Re: Hillingdon Tuition Centre, Providence Road, Yiewsley

I have been asked to update yourselves on the demolition of an existing brick annex building and the erection of a single storey brick workshop building to house a motor vehicle educational training facility and associated external hard and soft landscape works (involving the removal of four low grade trees) at the above address (4163/APP/2020/2212 refers) . Comments received to date are as follows:-

DESCRIPTION
PROPOSED SITE PLAN

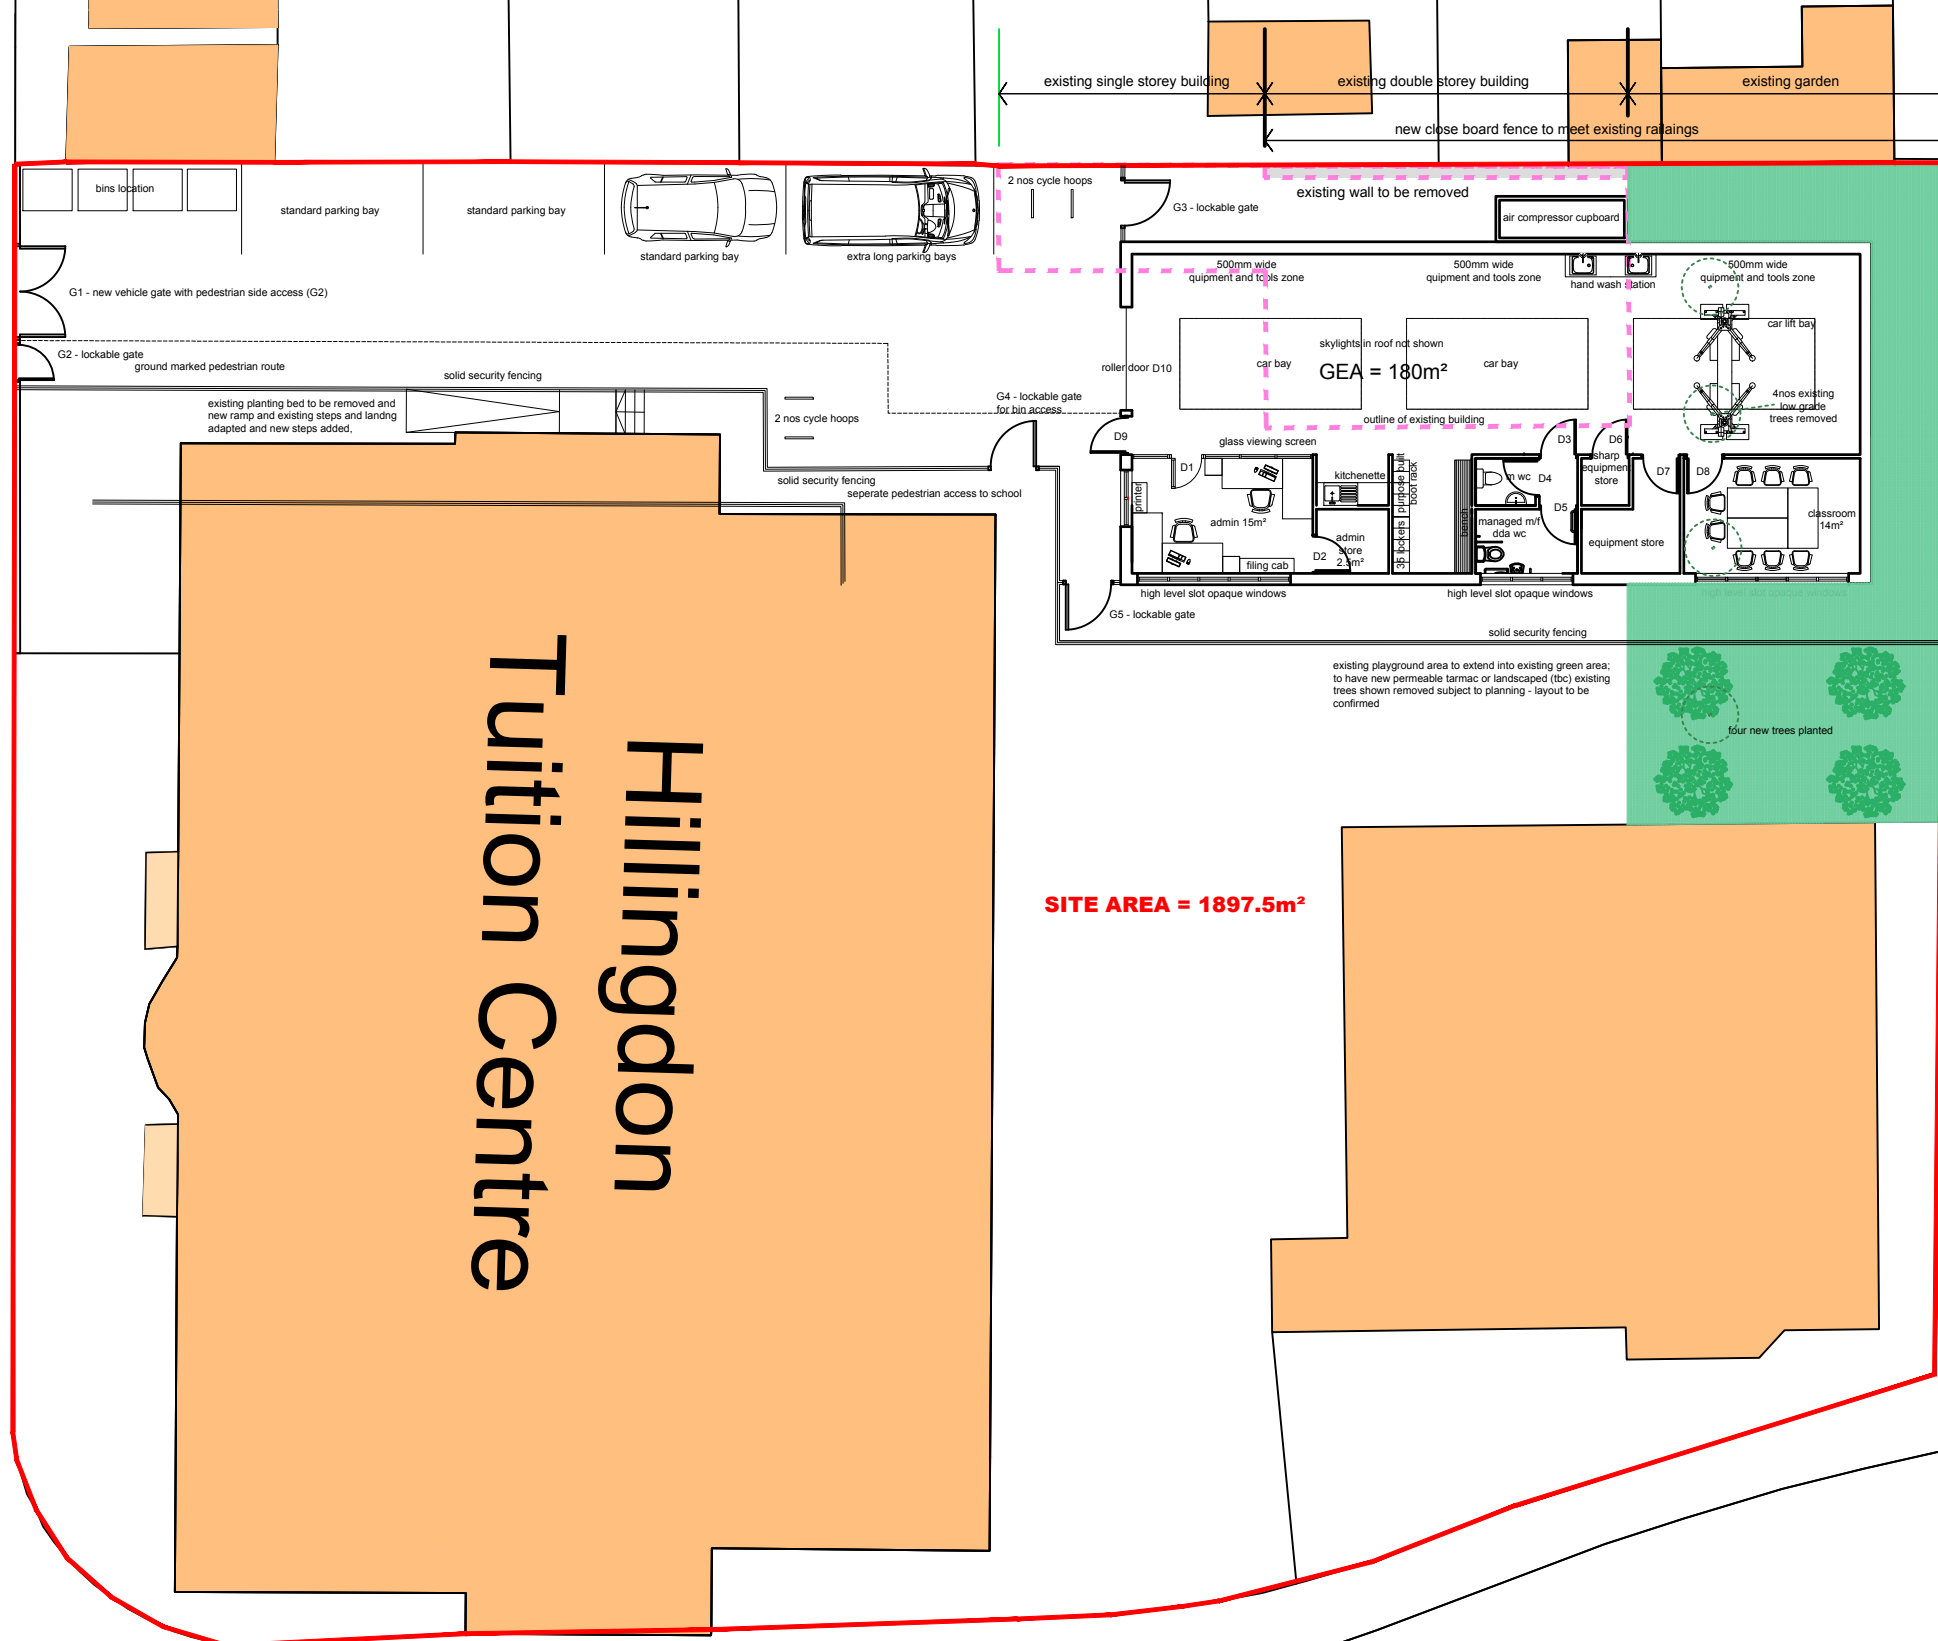
You mention that cycle parking will be shown on the site plan but I do not recall receiving anything further from yourselves. That said, this could be conditioned but as stated in my email of 26/8/20, we will need details of the staff

and student numbers to establish the appropriate level of provision that needs to be made for cycle parking in any condition (or indeed shown on a plan).

A number of residents have raised valid concerns about the type and amount of chemicals, fluids, substances etc. that will be stored in the building and also raised concerns over the potential for noise pollution etc. The floor plans show an air compressor cupboard adjoining the residential boundary (which has been omitted on the elevation plans) but I still do not have any details of the type of equipment that will be operated on site, pupil numbers, the amount and intensity of activities that will be undertaken etc. This is primarily a residential area and I do need some assurance on these matters. The plans also need to be consistent.

We have included four cycle hoops but more could be added. It should be noted that the students will all be bussed in, hence the minibus/van parking provision.

5) Updated plans and elevations (03 rev A, 04 rev A and 05 rev A) are attached as requested.
